Reservoir Catchment

Western Ditch

Southern Catchment

CLIENT DPS Limited	
PROJECT Wicks Farm Polytunnel Ford	
TITLE Proposed Levels and Drainage Sheet 3 of 6	
DRAWN PR	DATE Feb 2020
DESIGNED SB	CHECKED
SCALE 1:250 @ A1	PROJECT NO. 23314
	PAGE NO. 23
	REV D

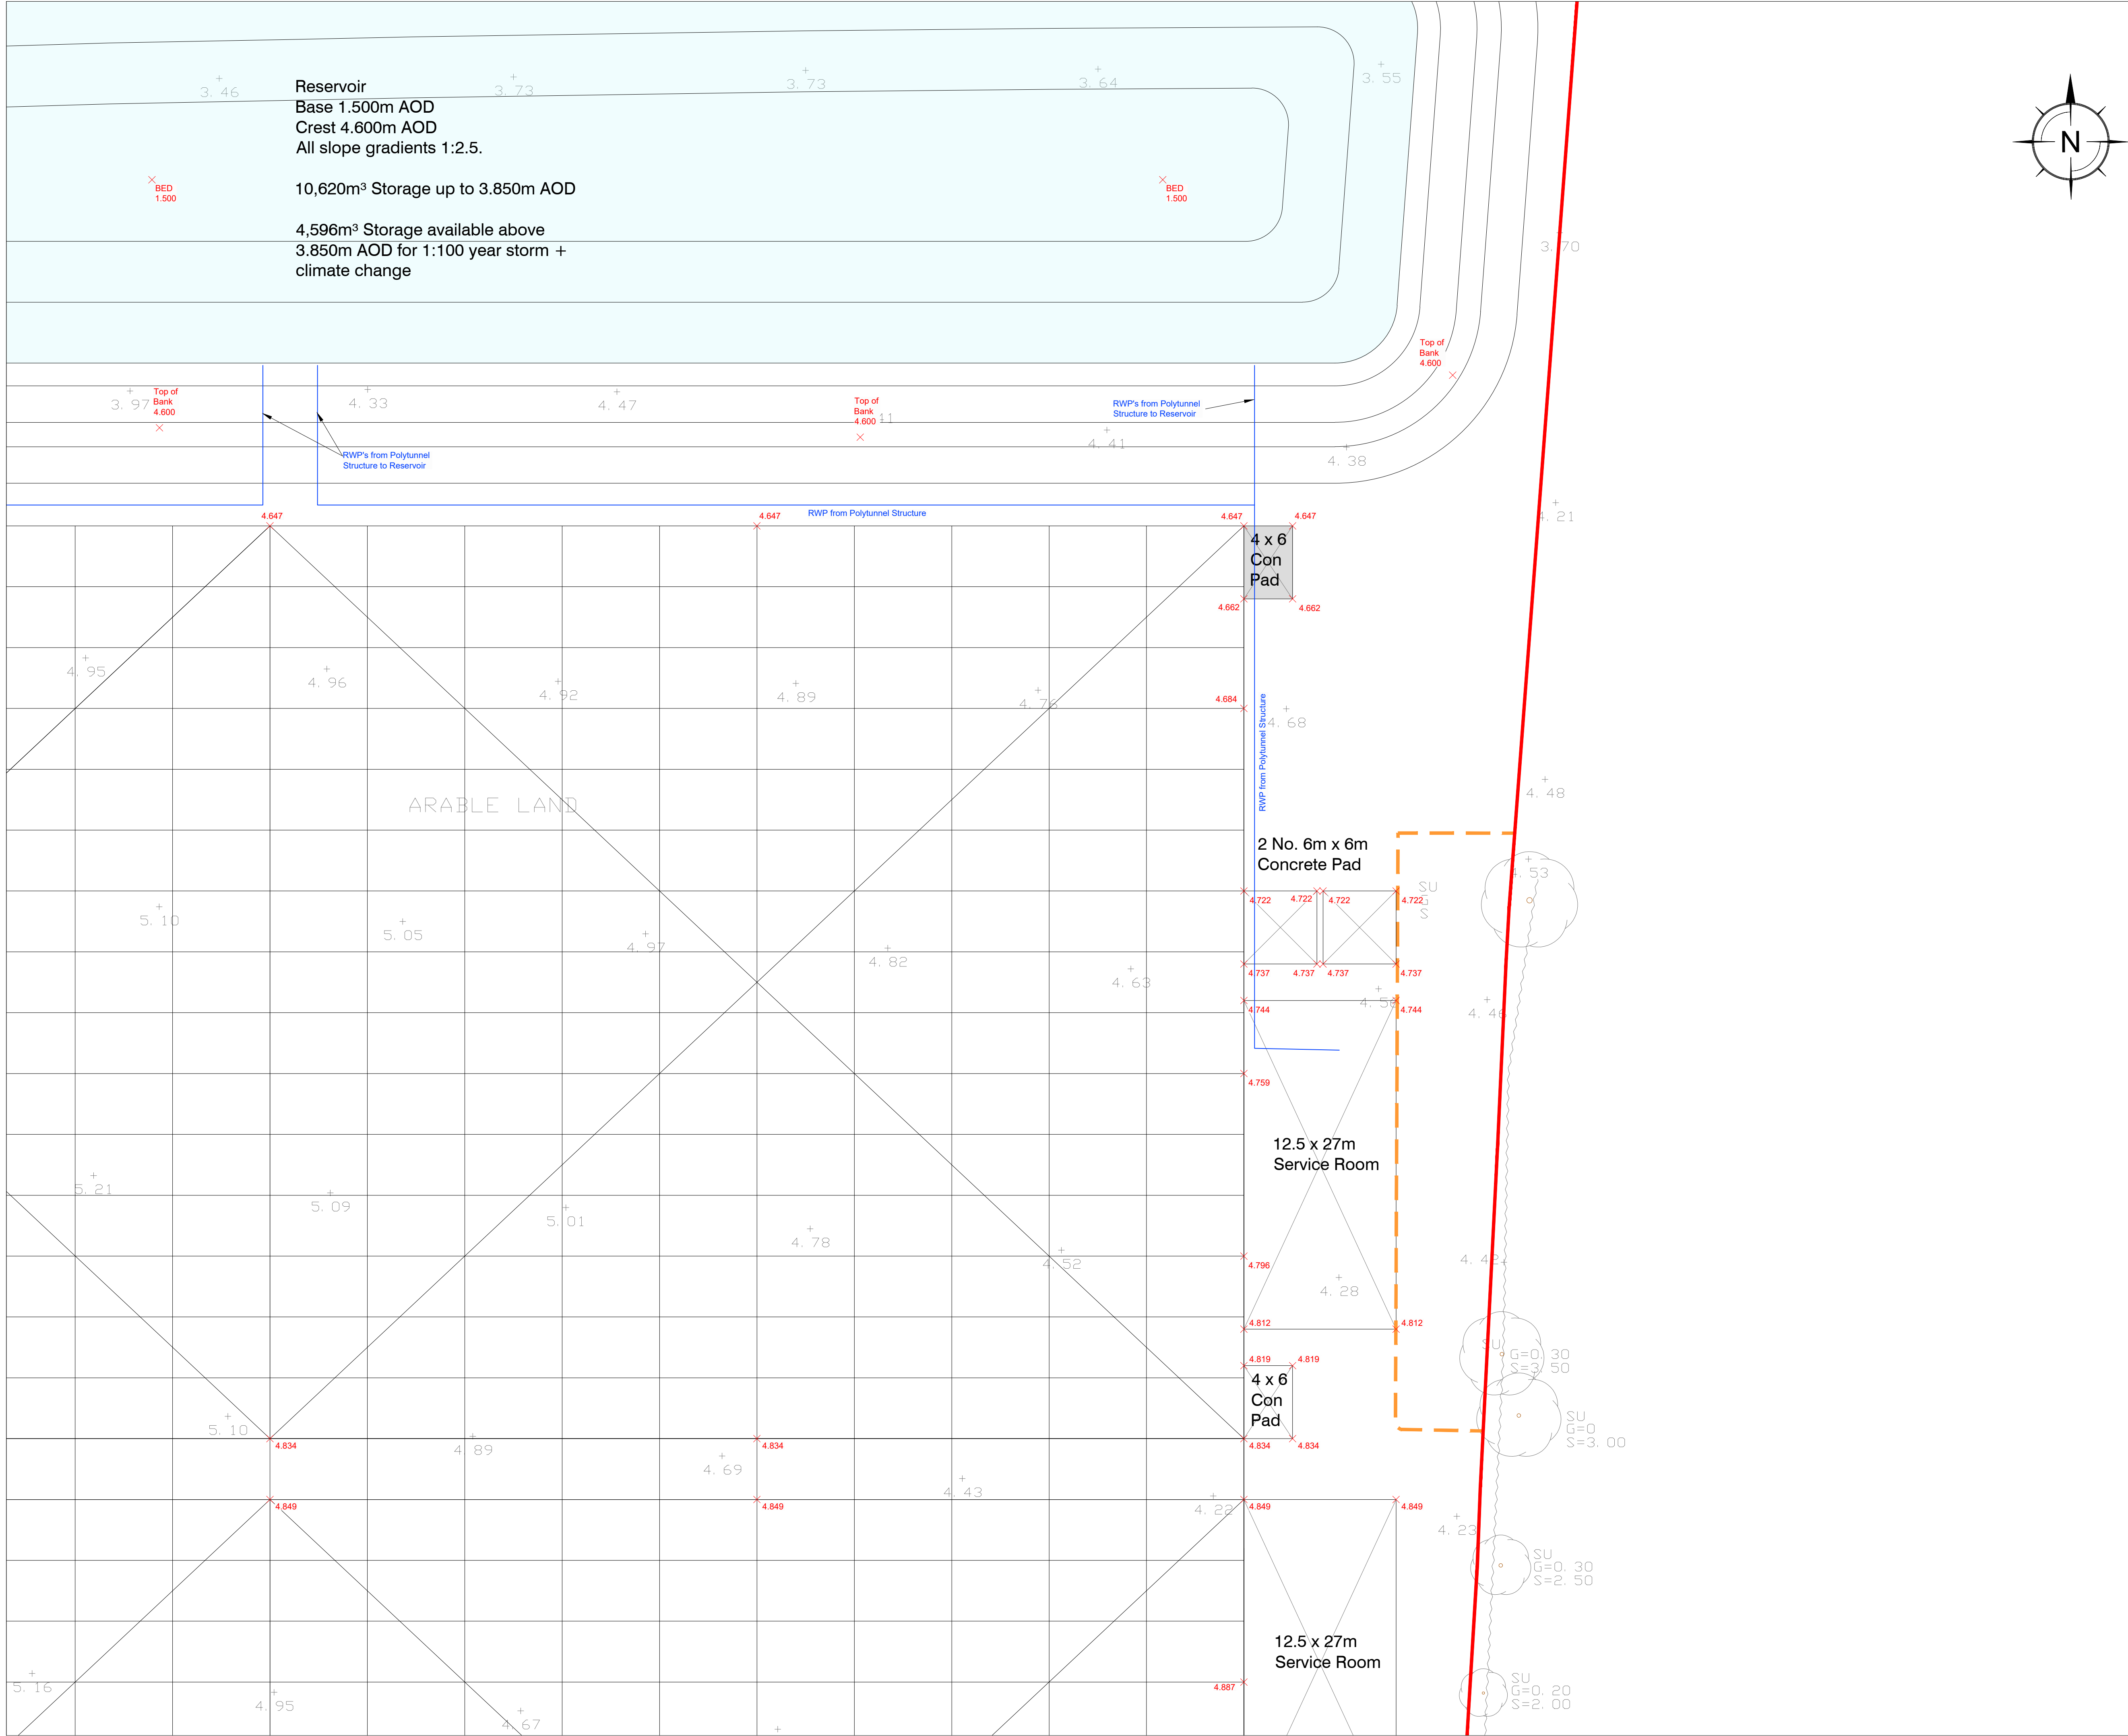
18. The pond/swale needs a slight gradient east to west (as has been employed on the upstream swales) to improve the hydraulics and ensure water movement. Please note the base level at the eastern end is currently lower than the base level at the western end. Adjust pipe inverts to suit.

19. Short swale – 225mm pipe connection – raise invert to increase freeboard ie. to say 4.270. Provide headwall construction details.
20. Pipeline 1.001 – provide 100mm freeboard between pipe invert and swale bed.

CLIENT	DPS Limited				
PROJECT	Wicks Farm Polytunnel Ford				
TITLE	Proposed Levels and Drainage Sheet 1 of 6				
DRAWN	PR	DATE	Feb 2020	PROJECT NO.	23314
INTEGRATOR	SB	CHECKED		DWG NO.	21
SCALE	1:250 @ A1			REV	D

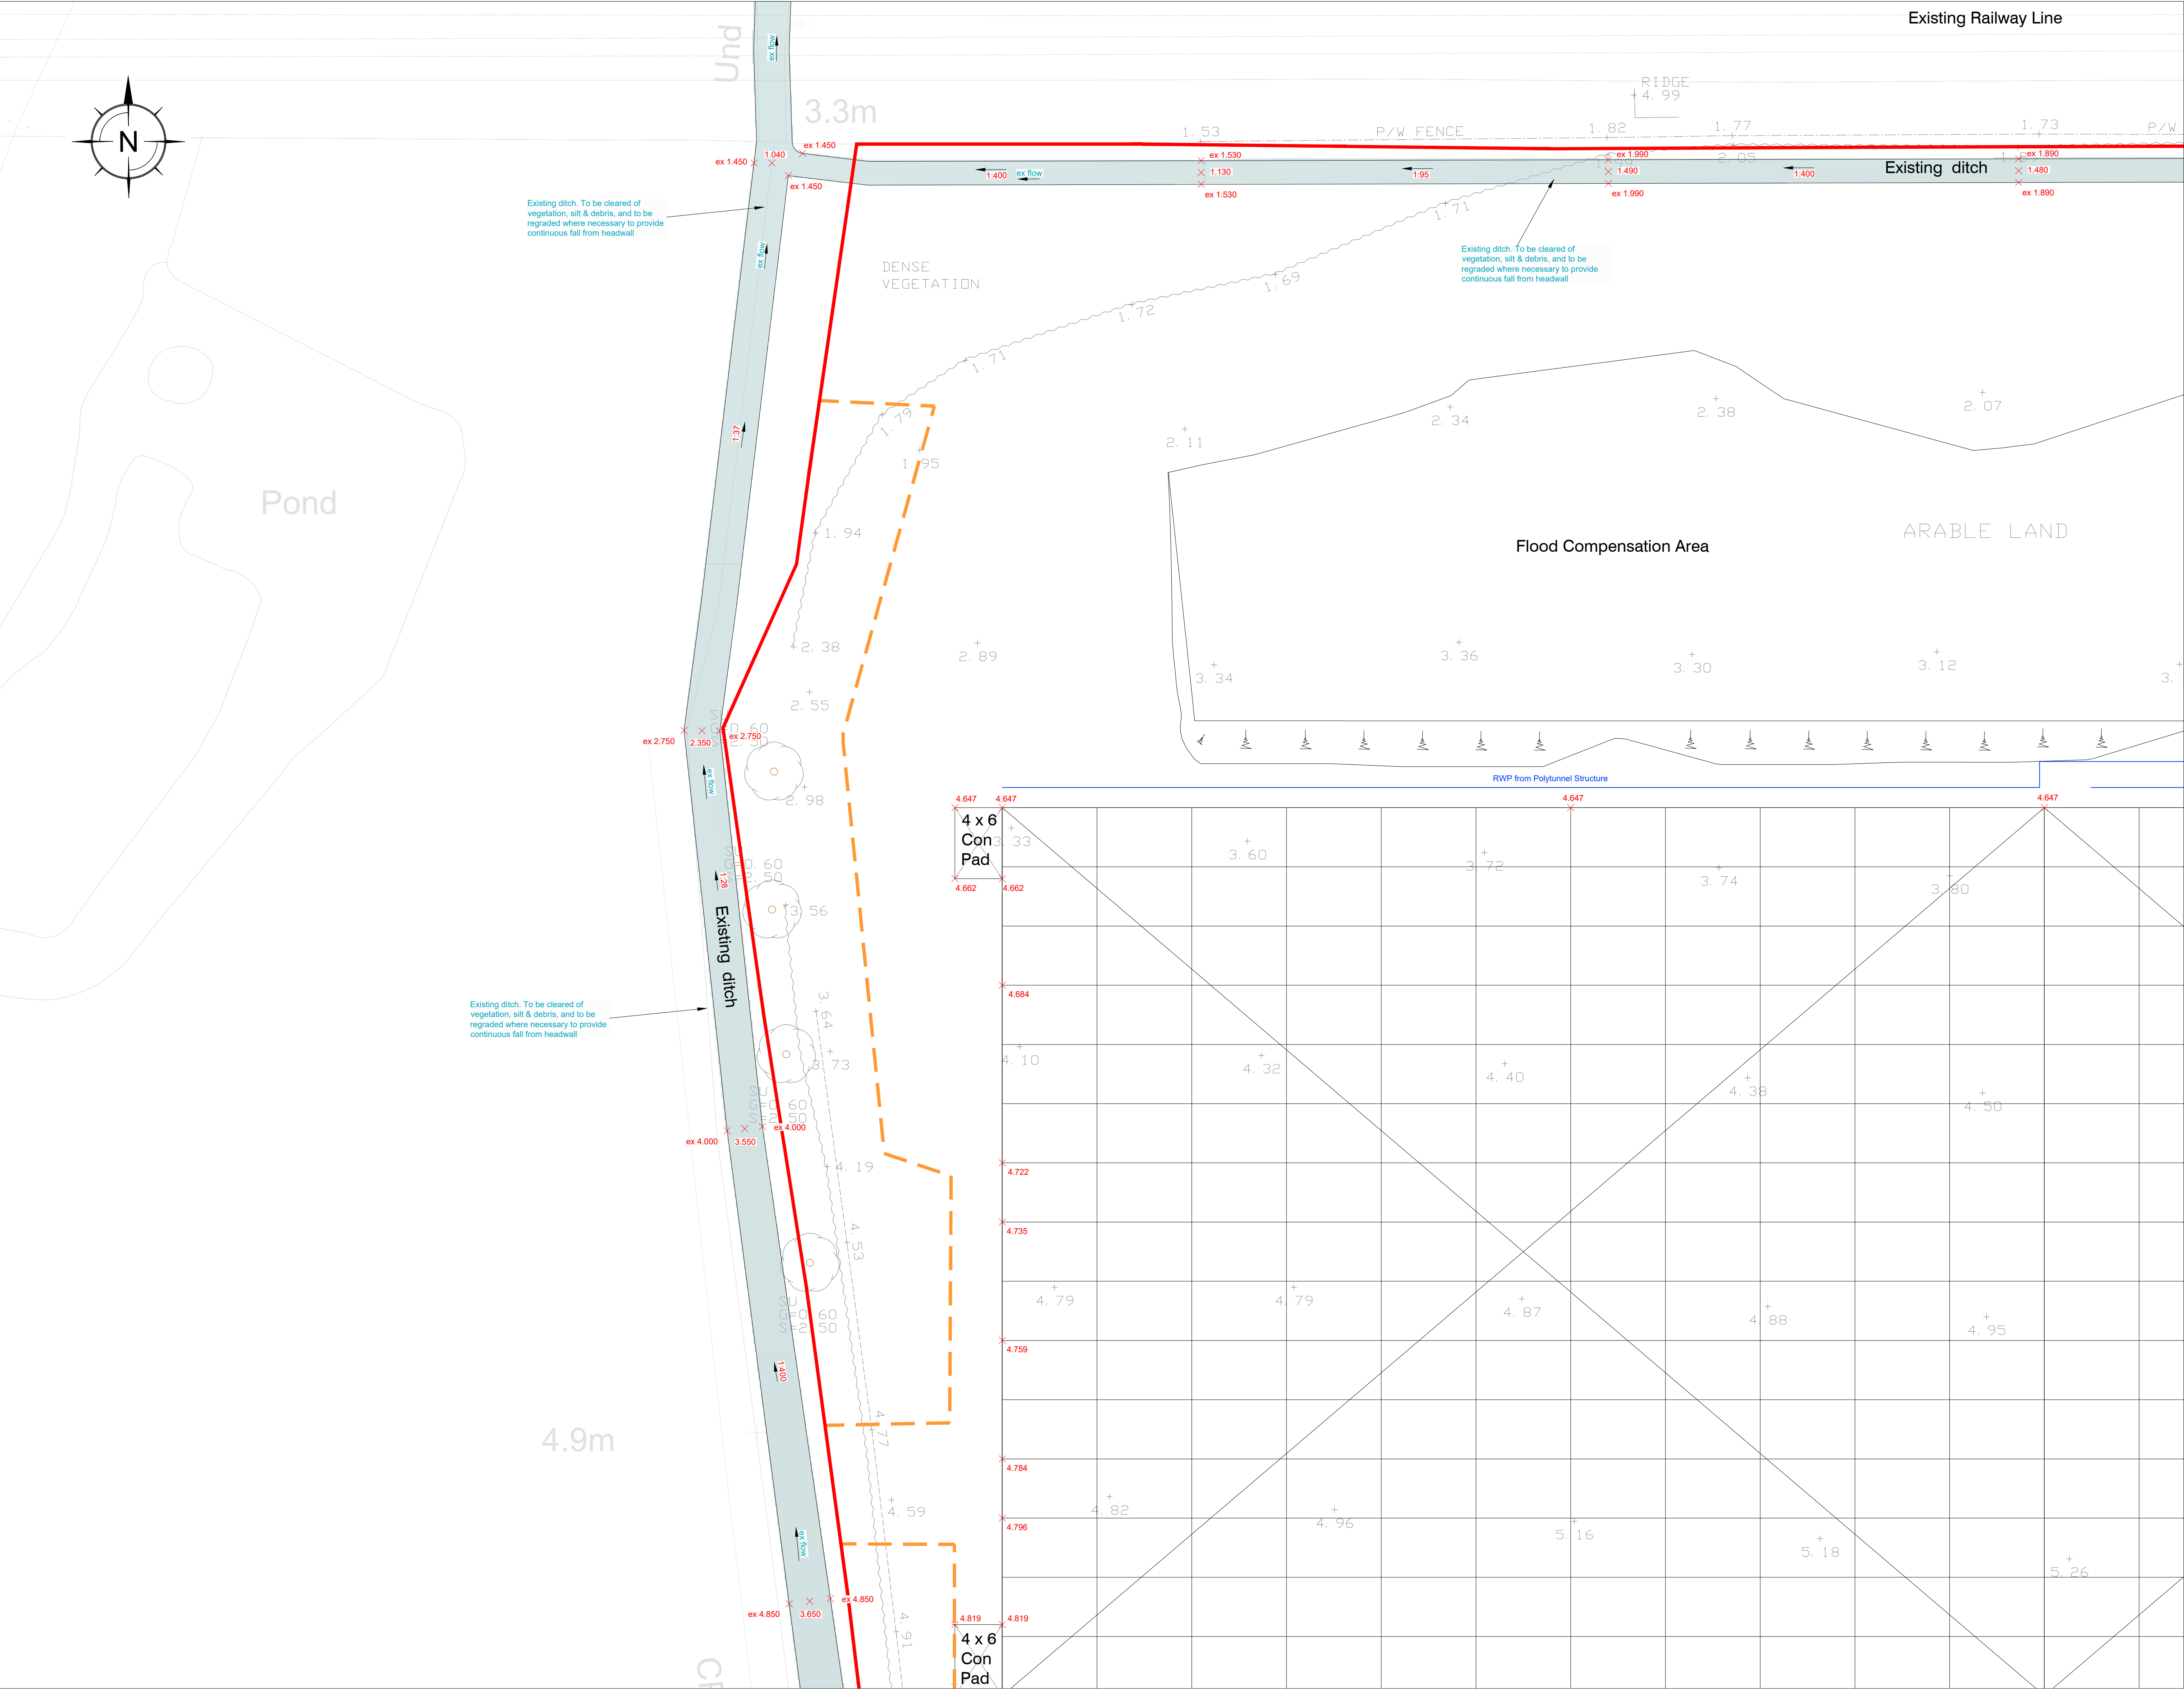
1. The northern boundary ditch in vicinity of the proposed reservoir is currently located on the other side of the network rail fence and not within the redline boundary. As previously suggested a 'new' ditch will be required within the red line boundary and running parallel to the network rail ditch. Please adjust drawings and provide a typical profile cross section. Land drainage consent is also required for the new ditch and headwall outlet.

11. Provide longitudinal section showing existing and proposed bed levels.
12. Show the infilled section to be reinstated, including the trees to be removed to facilitate this.
13. If the ditch is being significantly deepened in places then the banks may need reprofiling to avoid them being too steep. Please advise and provide cross sections if necessary. Please also confirm that the regrading/profiling proposals will not have a negative impact on existing trees and their root systems.
